CITY OF ALBUQUERQUE

June 27, 2024

**RE: Encanto Apartments – Bldg. I & J
2500 Eastman Crossing SE
Temporary Certificate of Occupancy
Engineer's Certification Date: 6/25/24
Engineer's Stamp Date: 5/18/23
Hydrology File: R16D101**

GRADING AND DRAINAGE PLAN  
REVISED COMMUNITY BUILDING AREA  
ENCANTO APARTMENTS  
MESA DEL SOL  
MAY, 2023

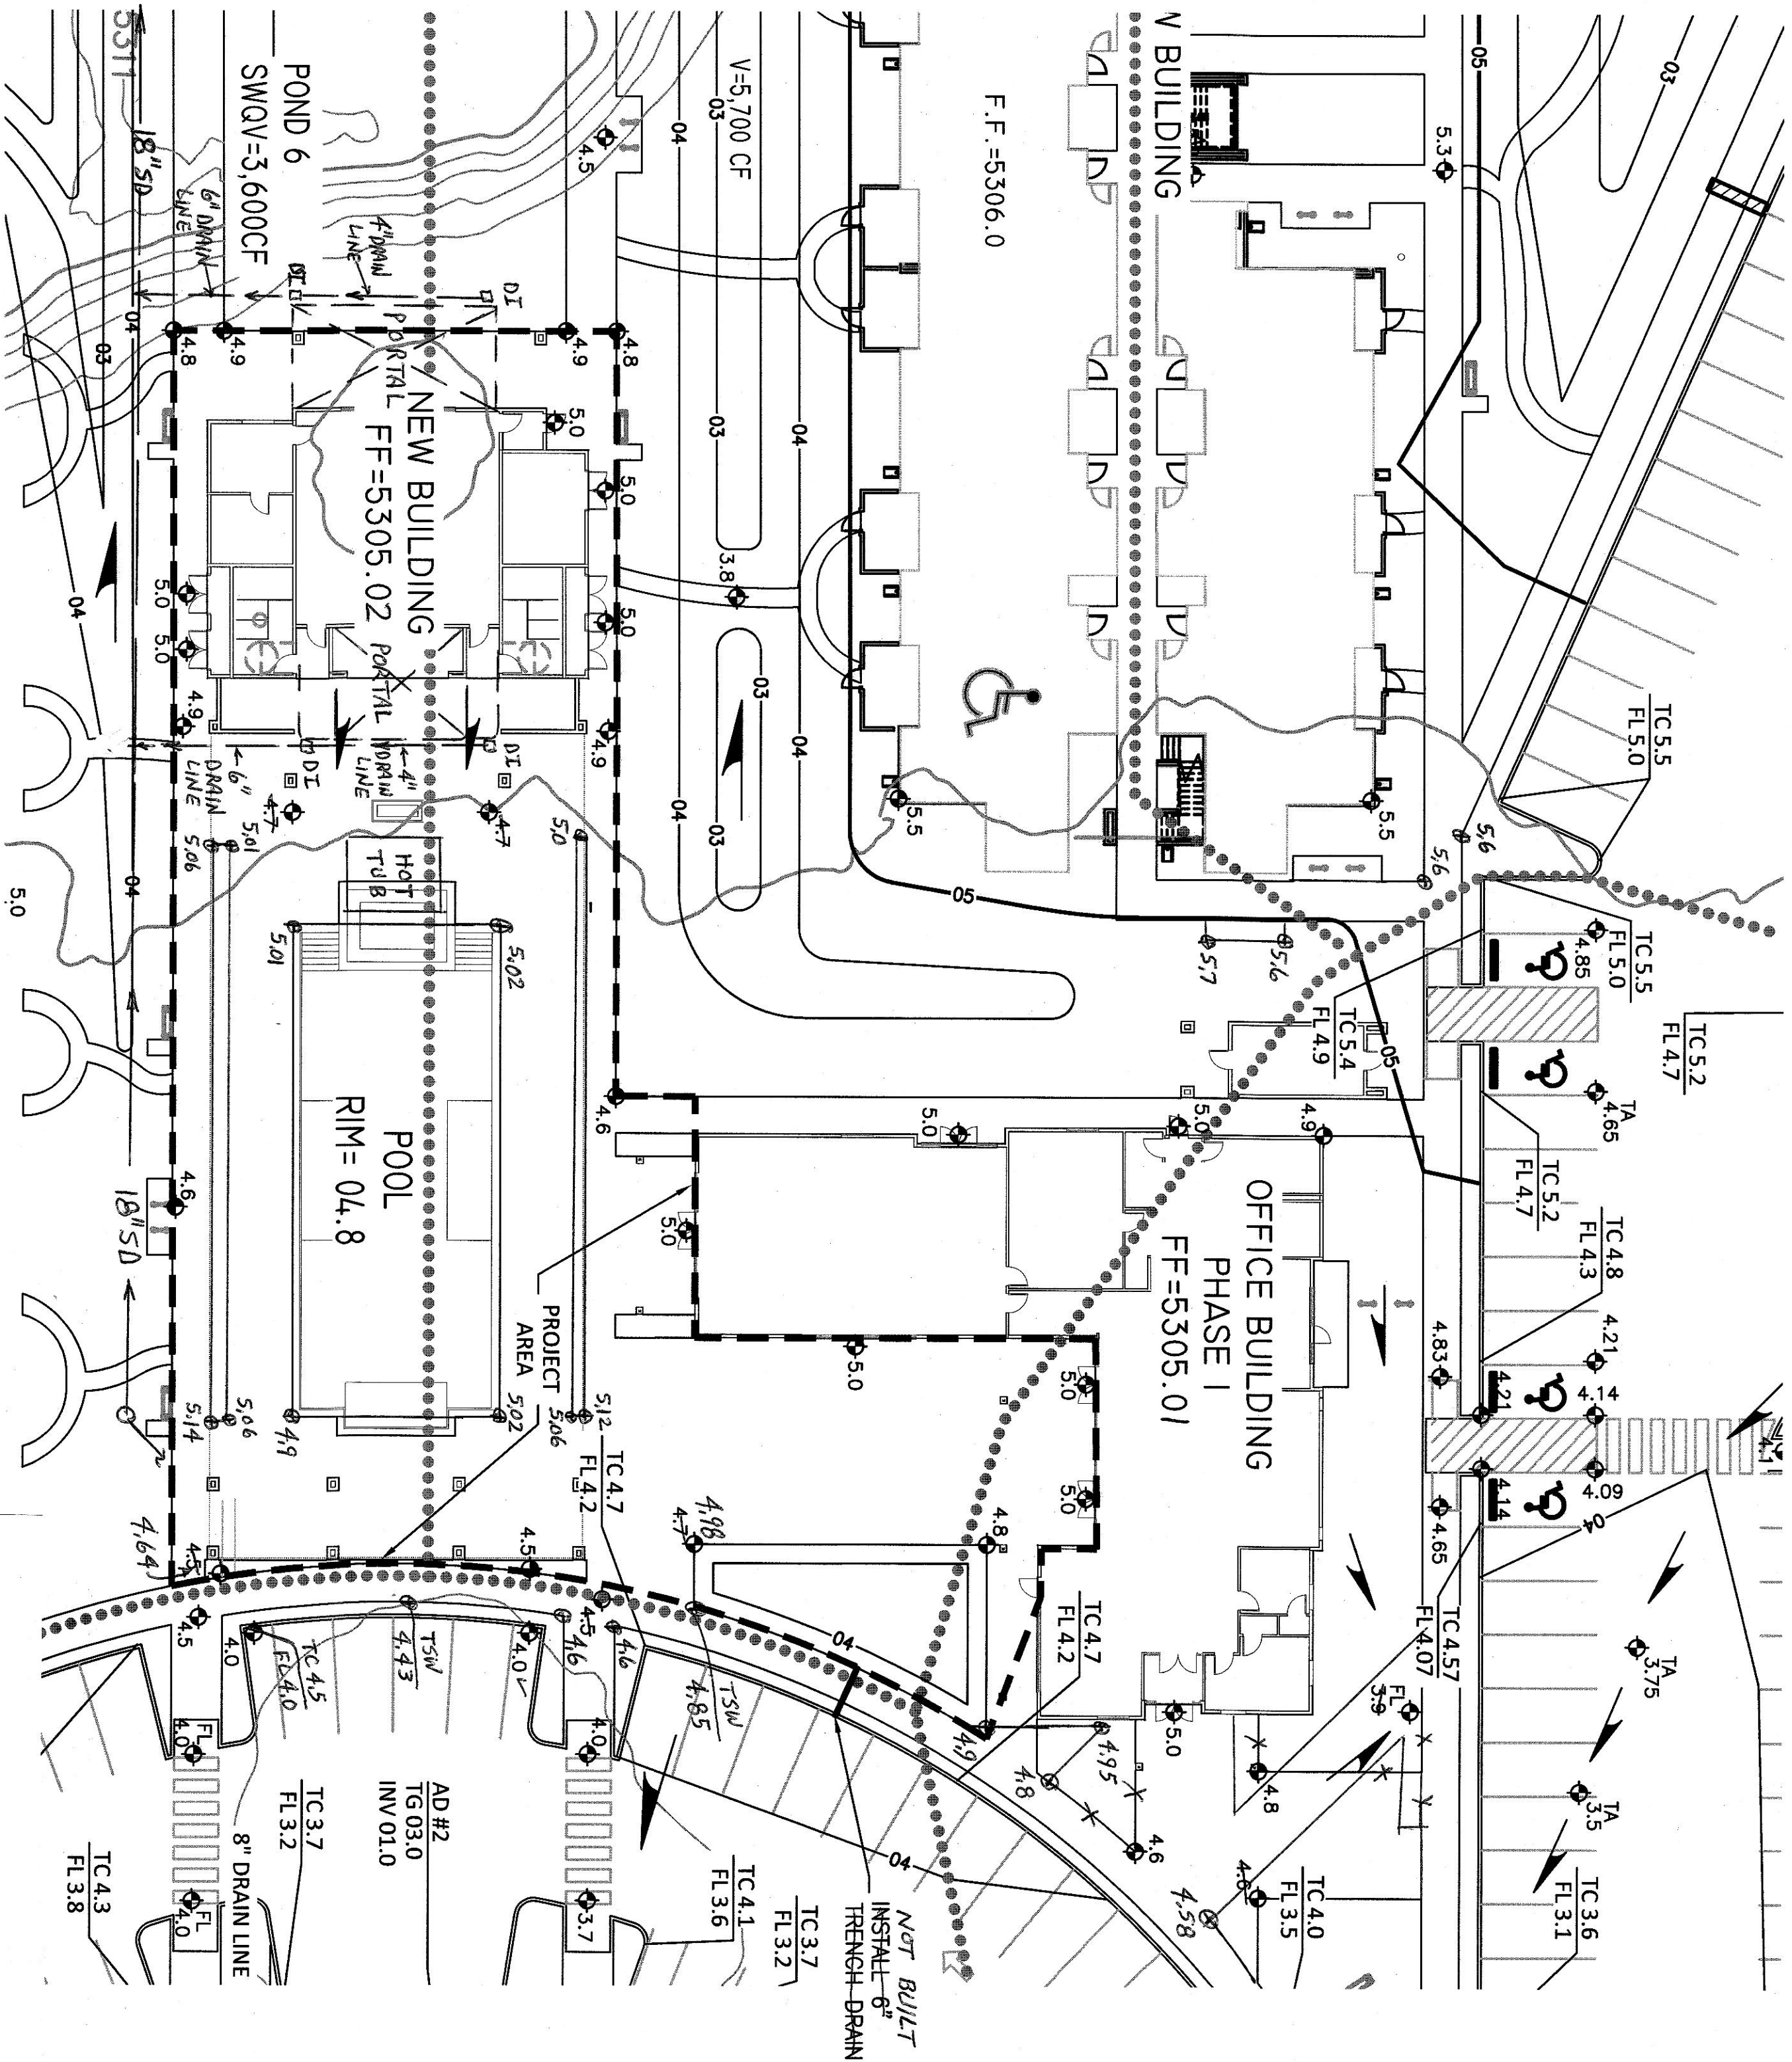
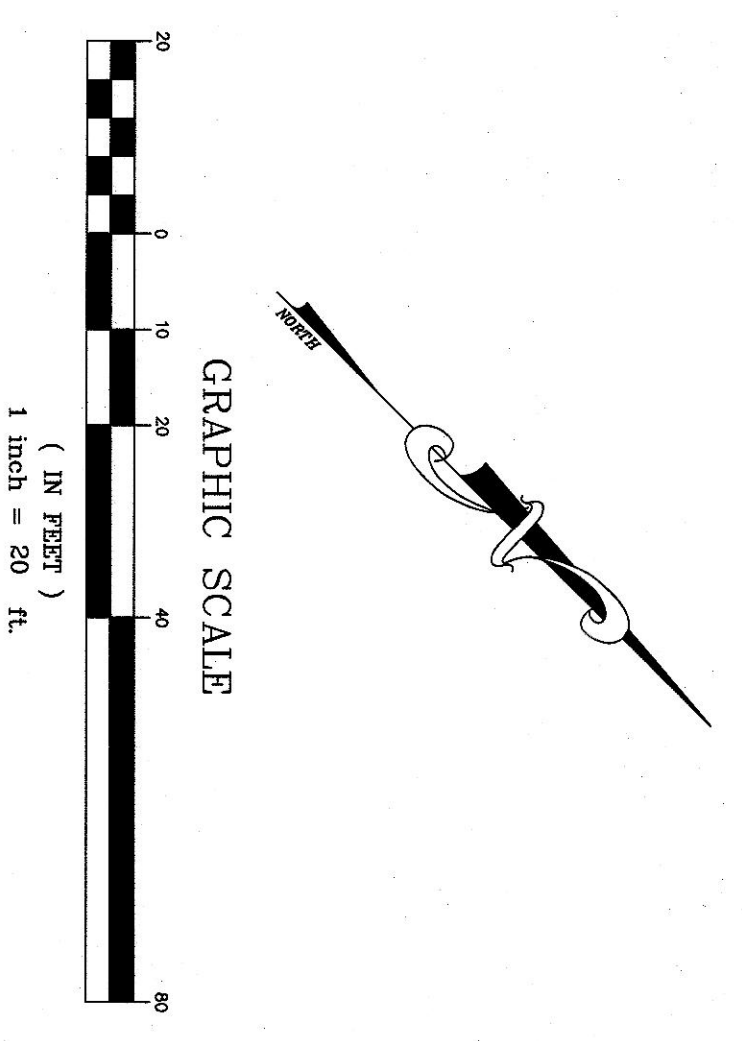
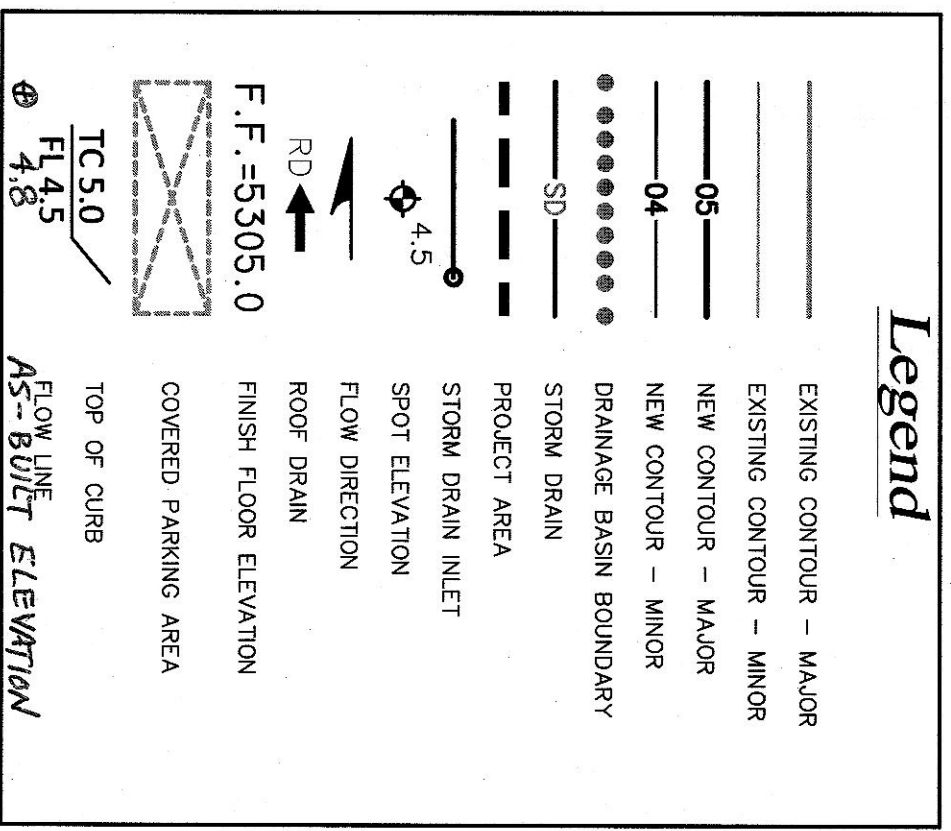
Install the steel plates on all of the sidewalk culverts where they are missing in the area and provide proof of installation to Hydrology when complete.
